Re: Project Solis —Tract J Bulk Land Plat for Mesa del Sol Innovation Park II (101605115947920604)
Project No: PR-2022-007805 (Third Submittal); SP-2025-00084
EPC Plan No: FP-2025-00004

On behalf of Project Solis, Stantec Architecture Inc. respectfully submits this supplemental submission of minor design revisions for final DFT review and approval. The proposed substitutions adhere to the preliminary approvals and findings stated in the EPC *Official Notice of Decision*, dated Aug. 21, 2025 (Plan# FP-2025-00004), and remain in full compliance with the City of Albuquerque IDO codes and regulations. The following revisions have been submitted concurrently to Mesa Del Sol ARC for Step II amendment review and approval.

Overview of Design Revisions:

11 REFUSE/SOLID WASTE ENCLOSURE
SCALE: 1/8" = 1'-0"

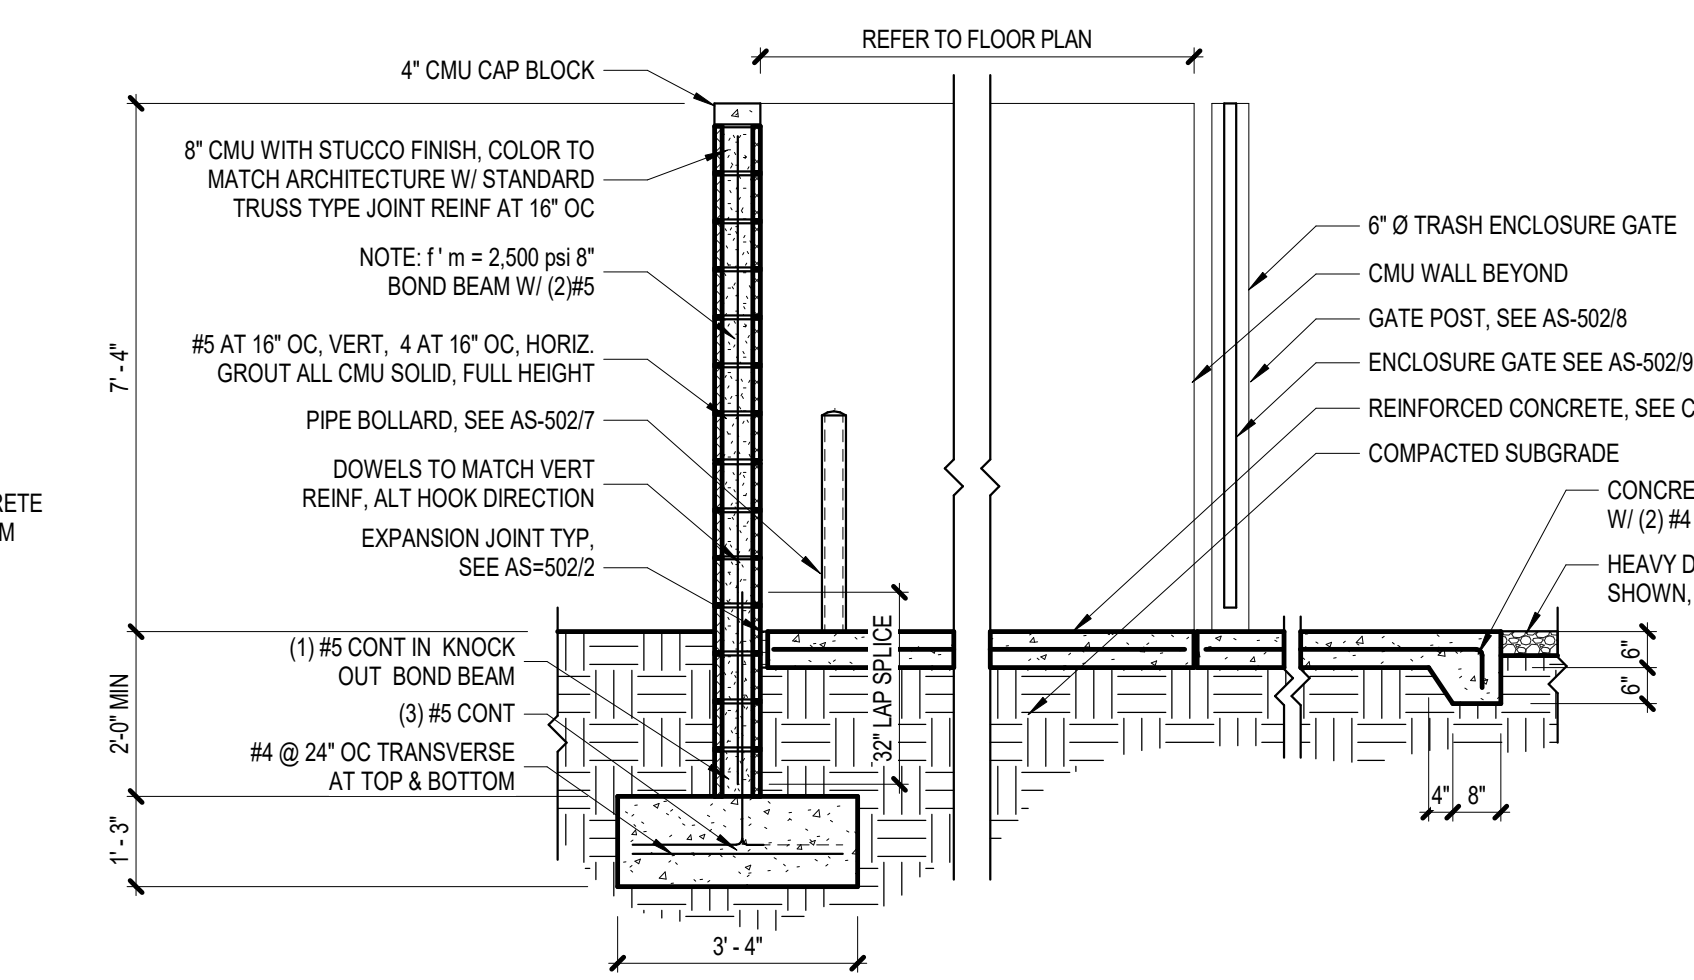
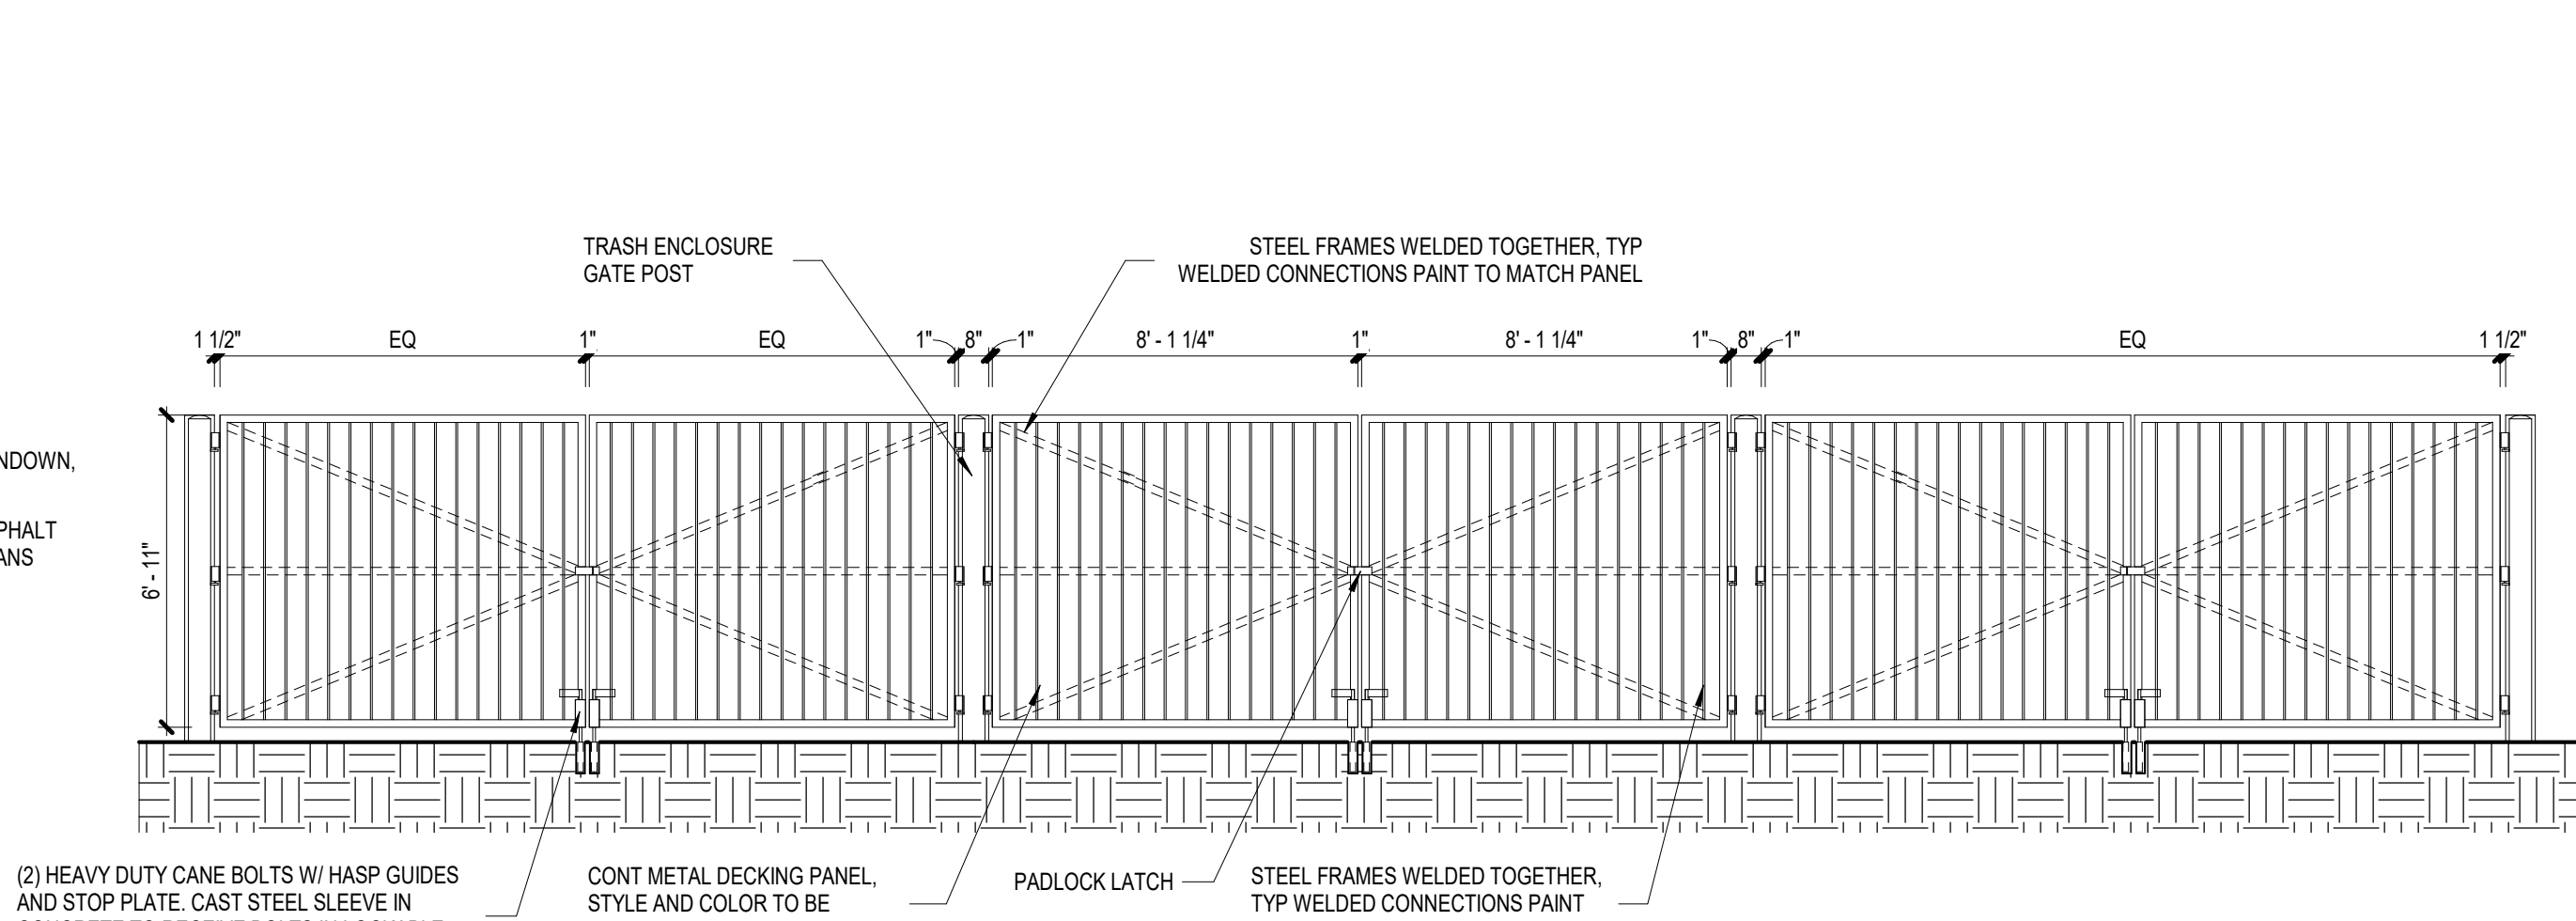
Trash Enclosure – The trash enclosures have been slightly relocated east, outside of the proposed secure fence line. The capacity of enclosures increased from 4 dumpsters to 6, while the size of the enclosures remains in accordance with City of Albuquerque design standards.
